PLANNING APPLICATION REPORT**REF NO:** BR/17/11/**LOCATION:** 48 Corbishley Road
Bognor Regis**PROPOSAL:** Childrens two storey playhouse (Resubmission following BR/211/10).**SITE AND SURROUNDINGS**

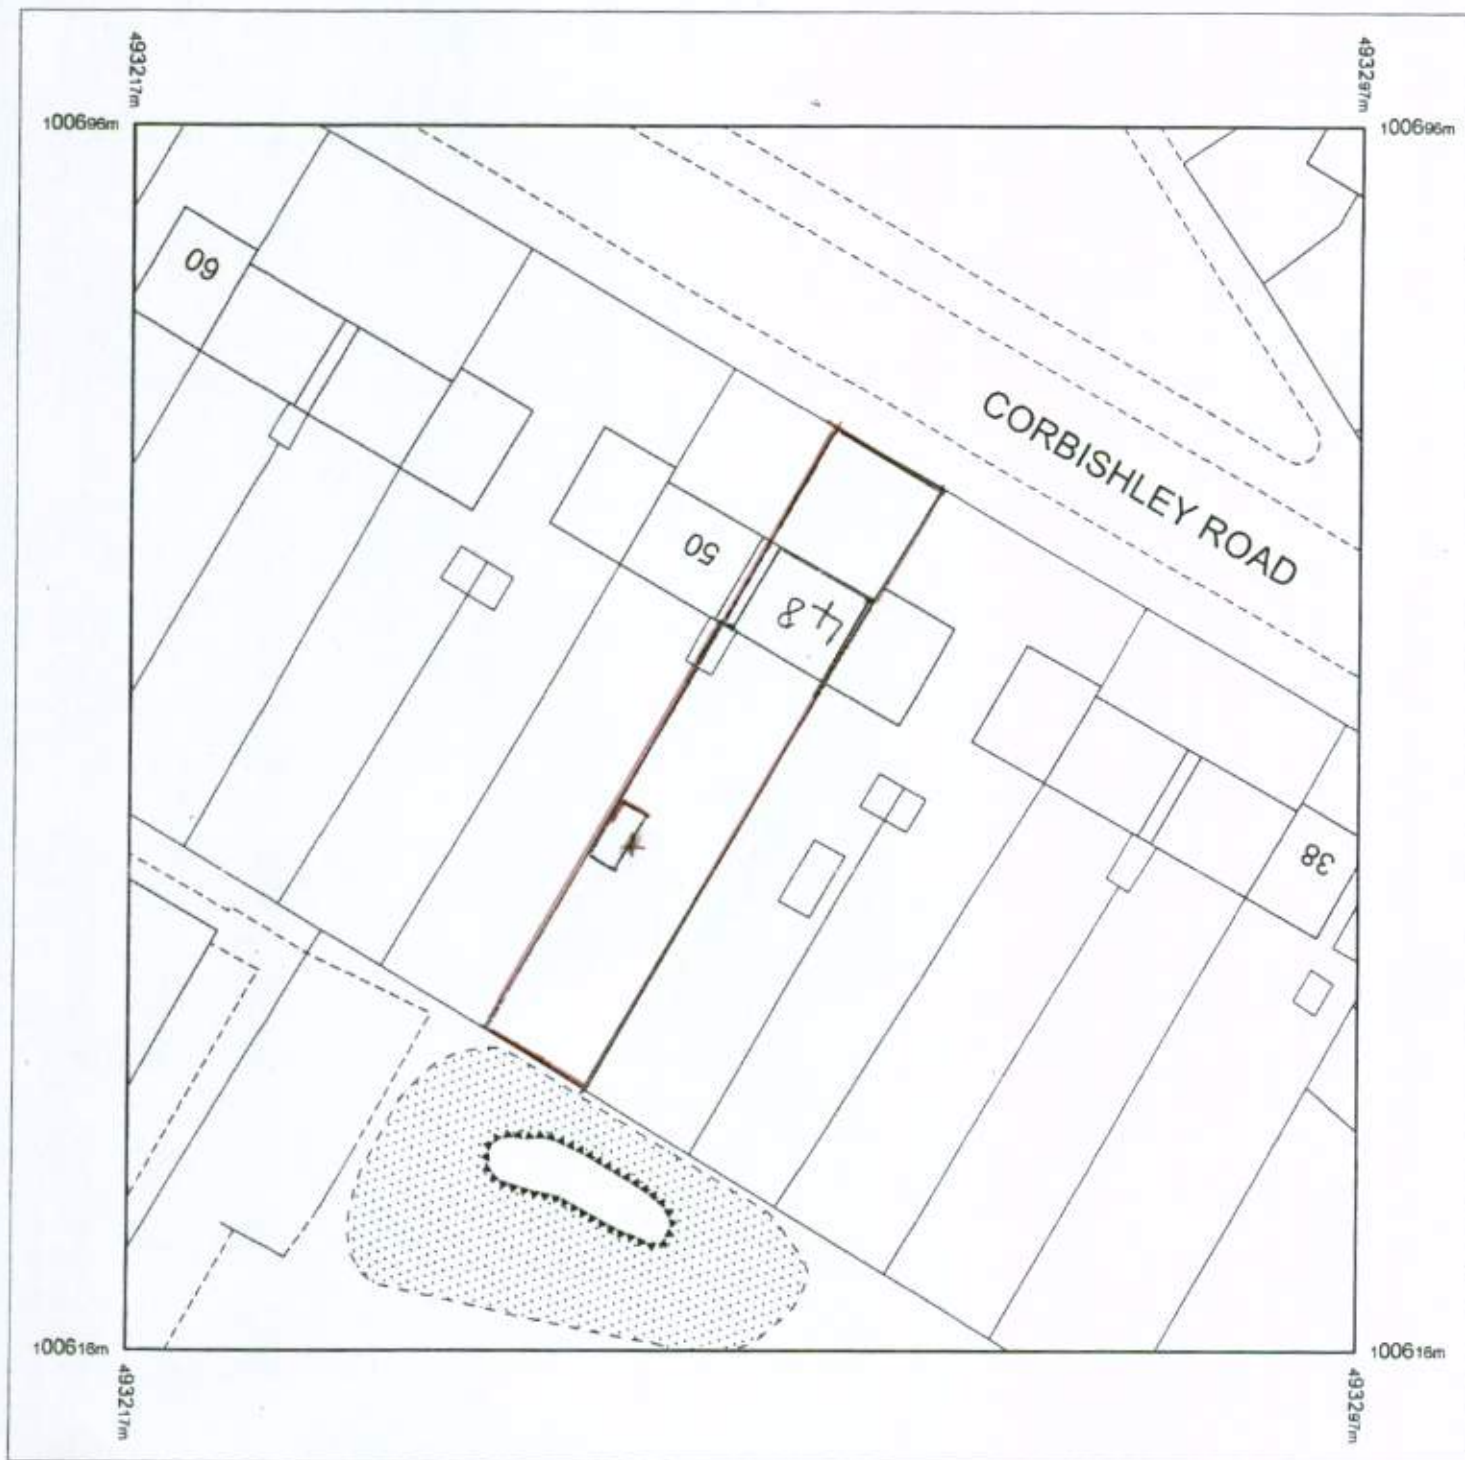
This re-submission seeks to address the issue of overlooking by introducing a close boarded fence screen approximately 1m high to the upper platform, and by re-positioning the slide to the eastern elevation. Whilst it is appreciated that this alteration will largely alleviate the issue of overlooking, it is considered that the additional height and bulk created by the screening is such that it would have an overbearing impact on the occupiers of neighbouring dwellings.

- 1 The playhouse structure in combination with its additional screening, would have a detrimental impact on the residential amenities of the occupiers of neighbouring dwellings due to its siting, size and bulk, contrary to policy GEN7 of the Arun District Local Plan.
